Alan Varela, Director

April 14, 2025

**Re: Sawmill Building A at 1904 Bellamah Ave NW  
Erosion and Sediment Control Plan  
Engineer's Stamp Date 4/2/2025 (J13E044A) SWQ-2025-00016**

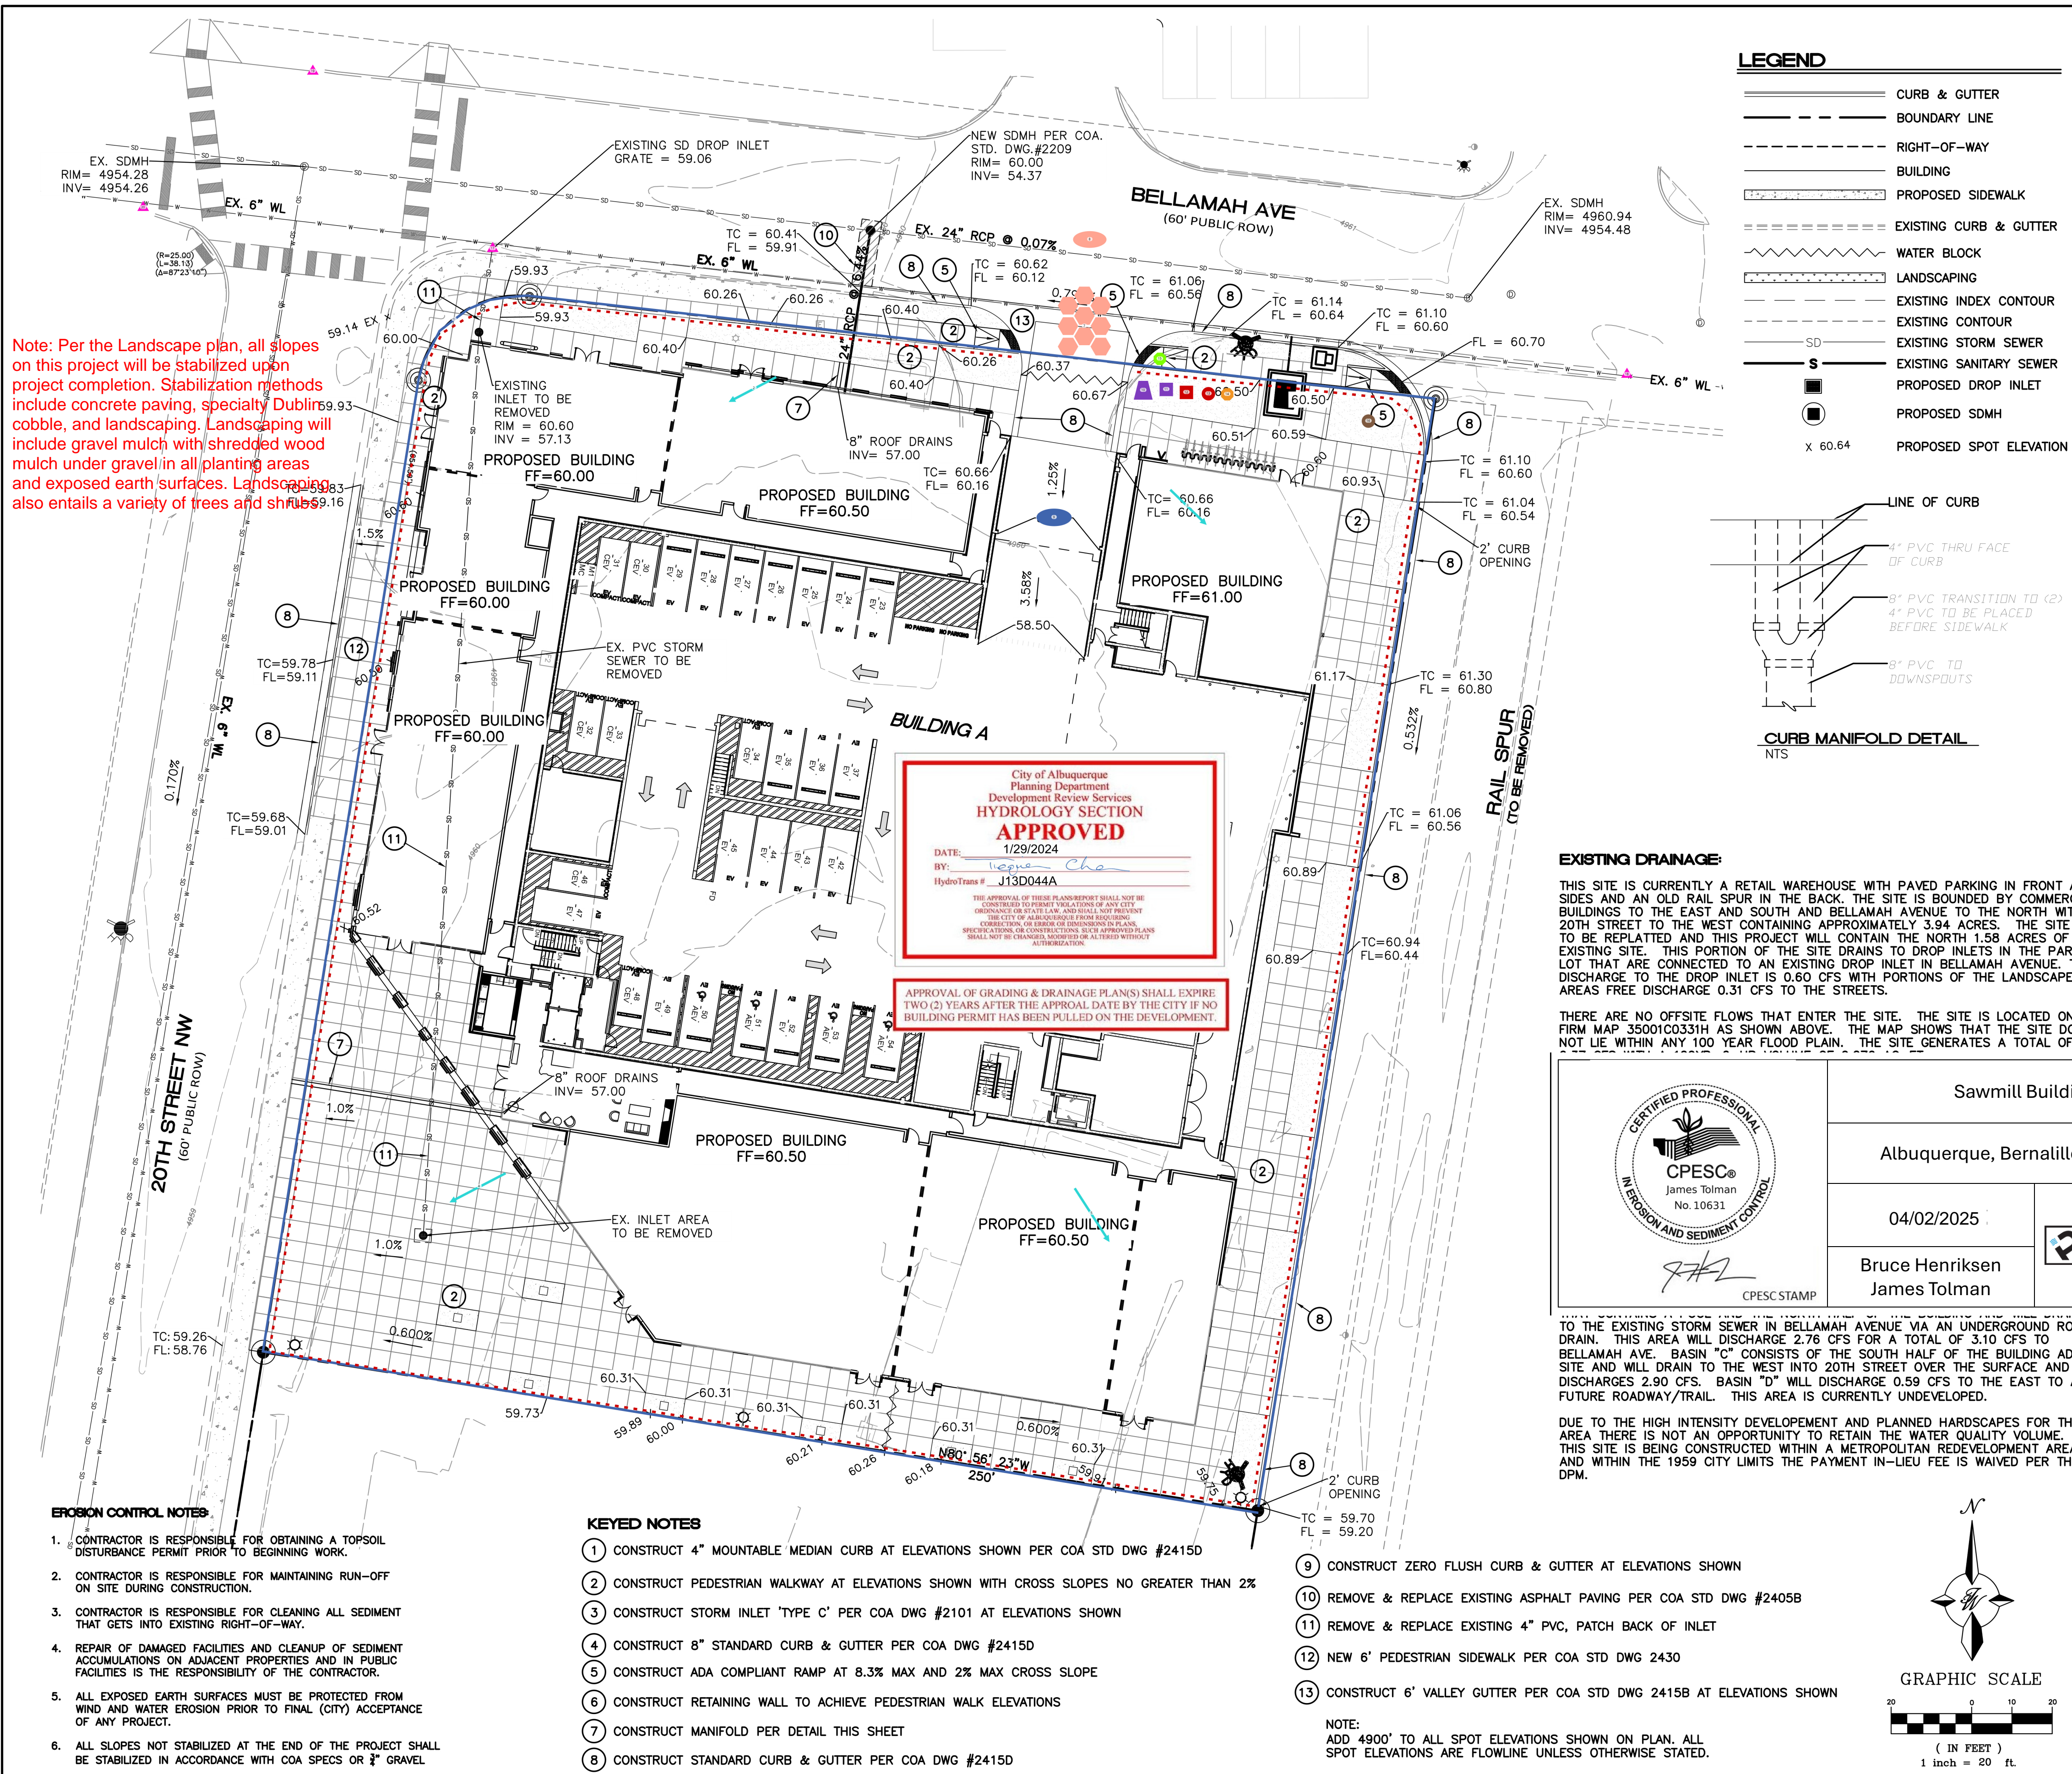
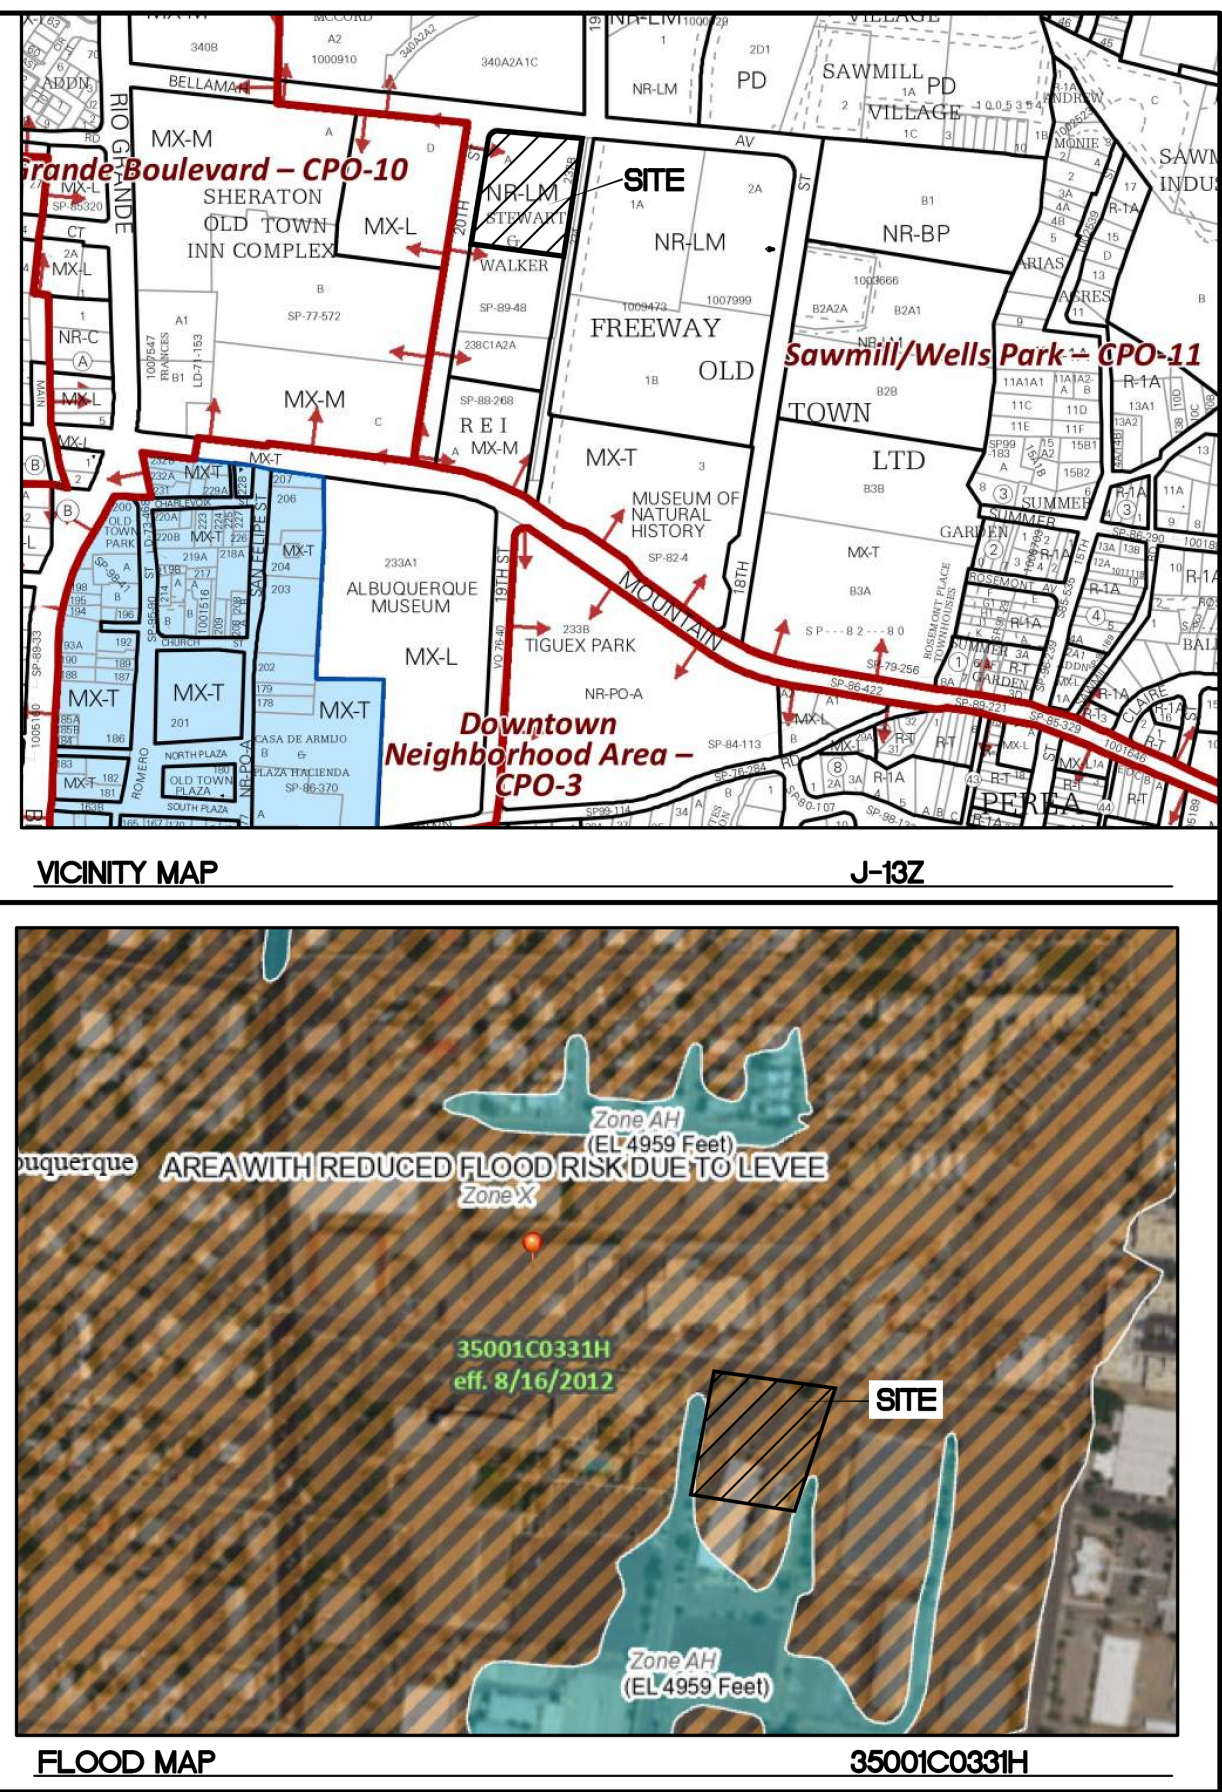
1. The SWPPP must include site-specific interim and permanent stabilization per CGP 9.6.1.c.i. The Landscape Plan satisfies this requirement for the north half of this 3.9-acre site, but specifications for stabilization of the south half are missing from the ESC Plan. In talking with Jim Long, he says he has approved plans for the south half of this property. If so, include those improvements on this ESC Plan showing the "Conditions for Terminating Permit Coverage" that will satisfy CGP Part 8.2. Provide a construction specification and schedule on the ESC Plan to stabilize any disturbed areas not covered by the Landscape Plan.
2. Update the engineer's stamp date on all sheets each time a change is made to any of the ESC plan sheets.
